KITTITAS COUNTY

DEPARTMENT OF PUBLIC WORKS

September 27, 2016

County Survey review of Maclsaac Short Plat 16-000003

MacISAAC SHORT PLAT  
 PART OF SECTION 34, T. 20 N., R. 15 E., W.M.  
 KITTITAS COUNTY, WASHINGTON

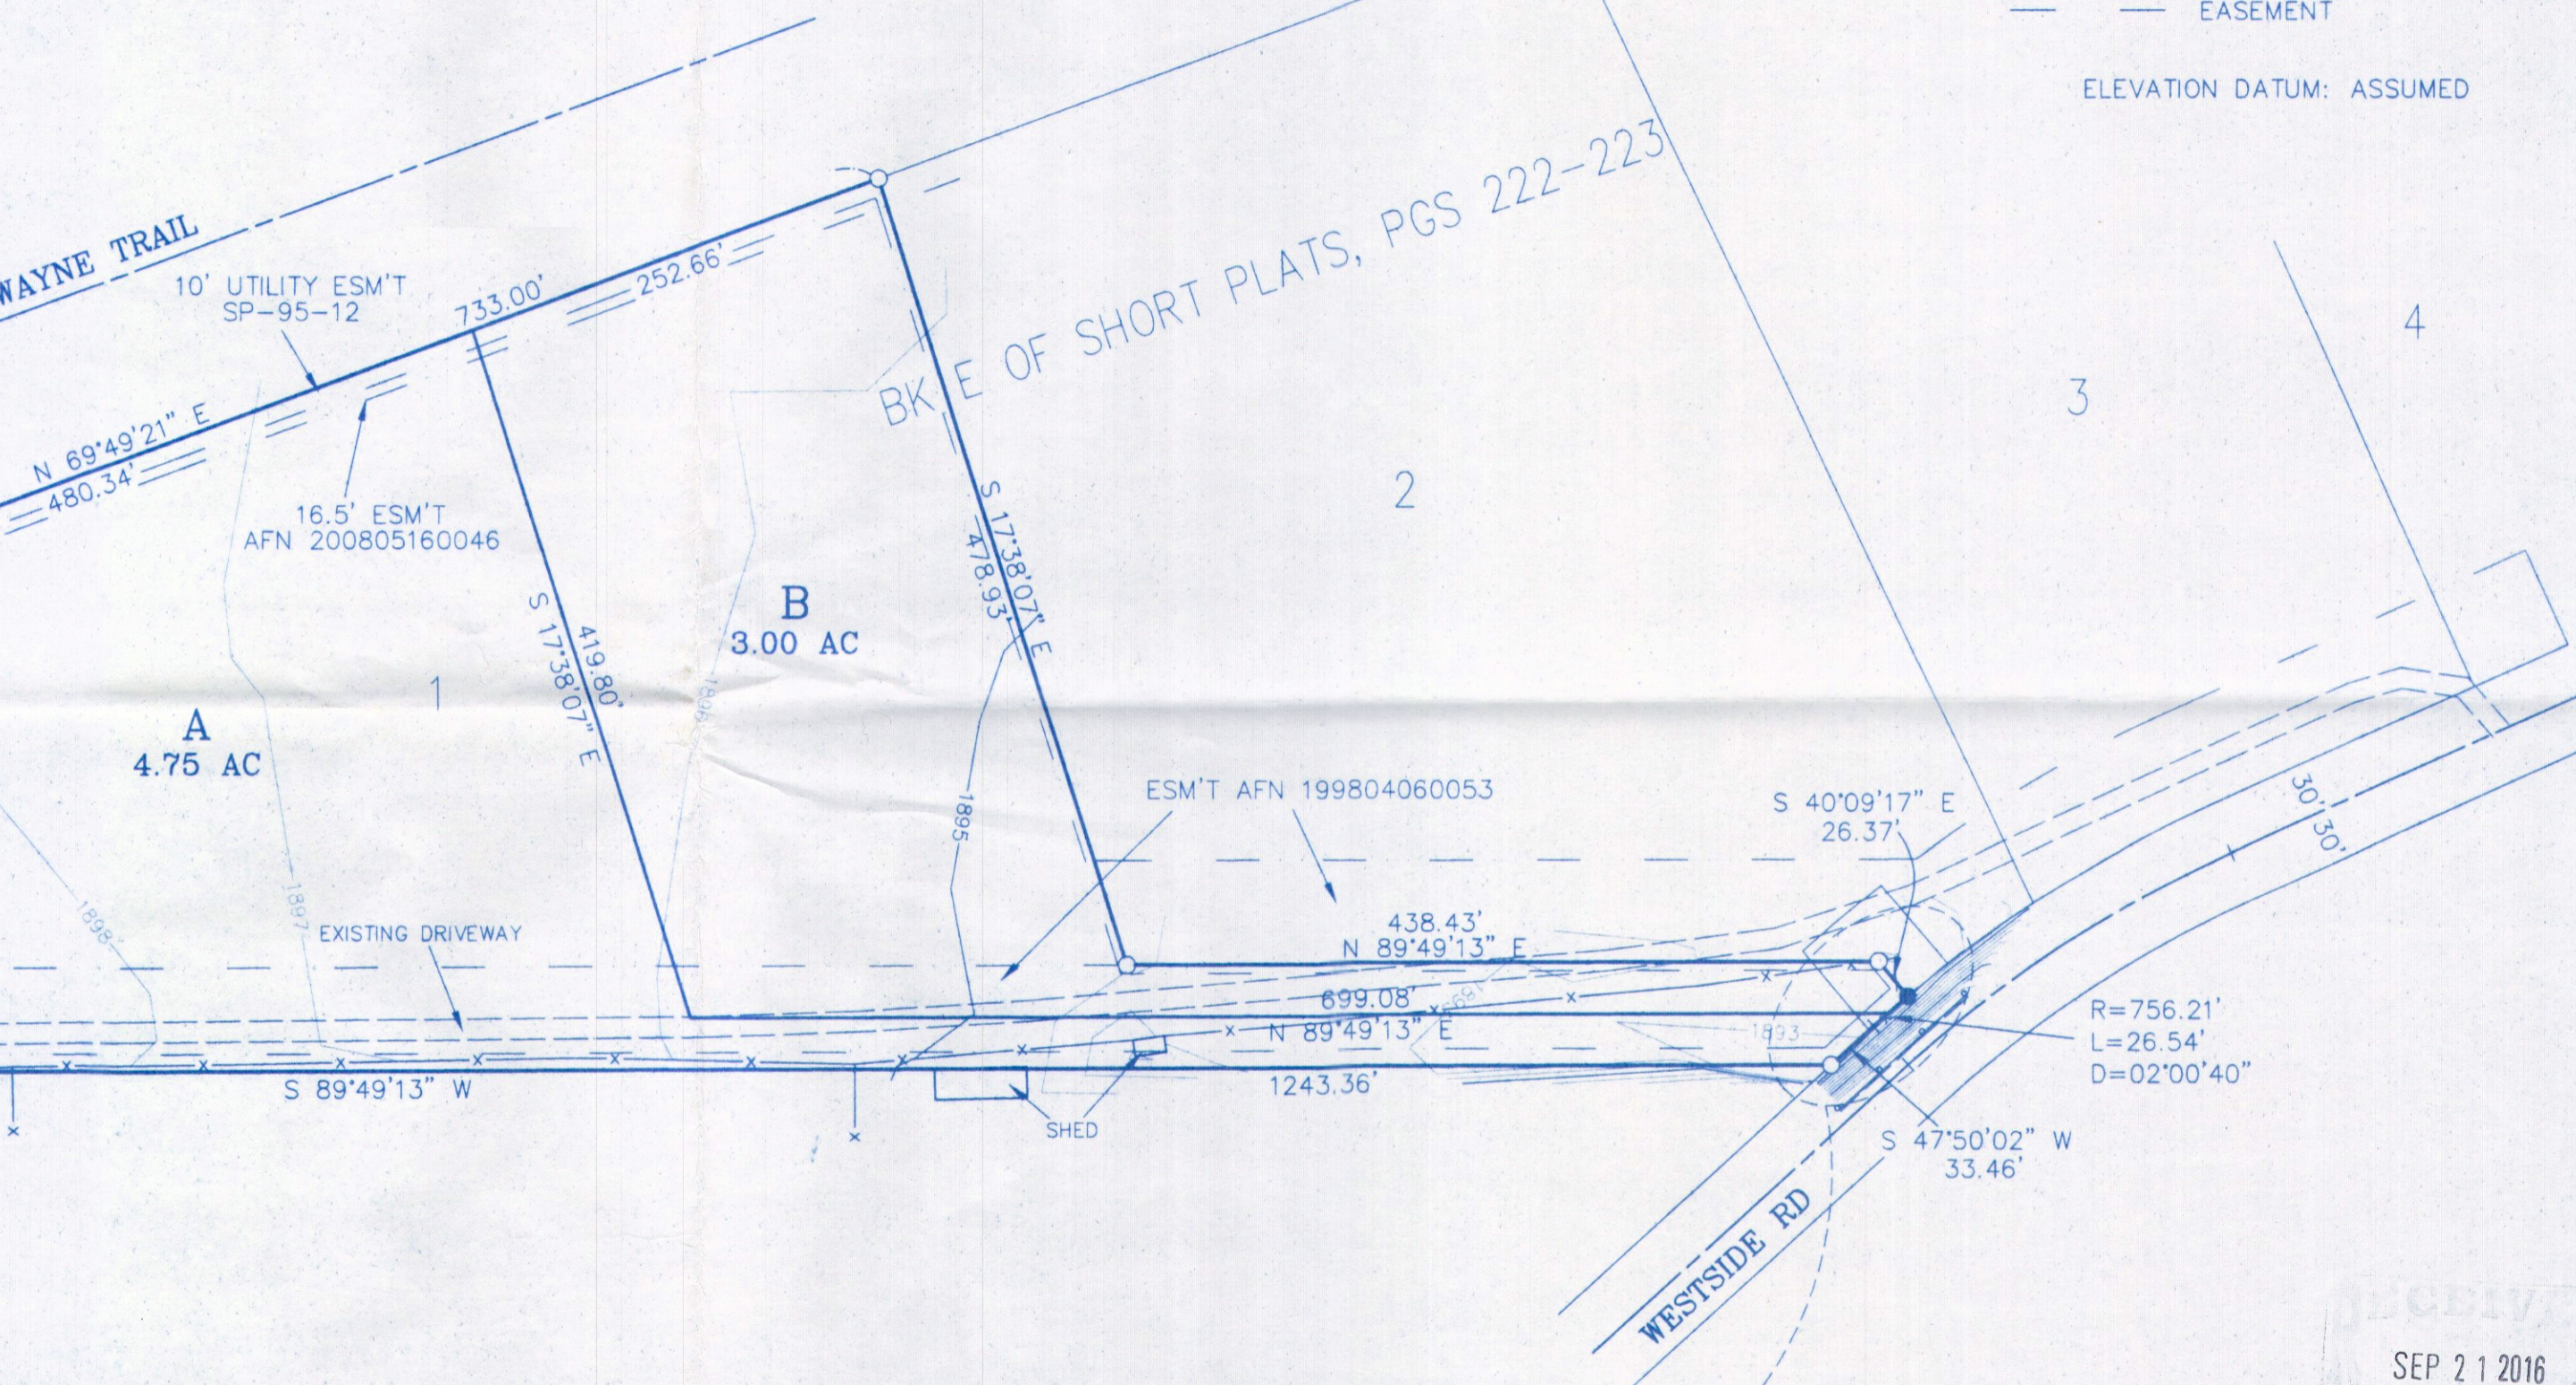
1. The box shown at the Easternmost boundary should be labeled as "60x60 Driveway Easement AFN:199712160006"
2. Clean up the linework around the label "N89°49'13"E 699.08" per DNR scanning requirements.
3. Easements AFN199804060053 and 200805161146 should list the purpose of the easement. (access? Ingress and egress? Access and utility?)
4. Change the label of Westside Rd to include ownership and surfacing (EX: Westside Rd county R/W – asphalt)
5. Include dimensions detailing the amount of trespass of the Sheds to the South.
6. Replace the legend note "Found Kitz Pin"" with "Found Pin and Cap "Kitz #16915"
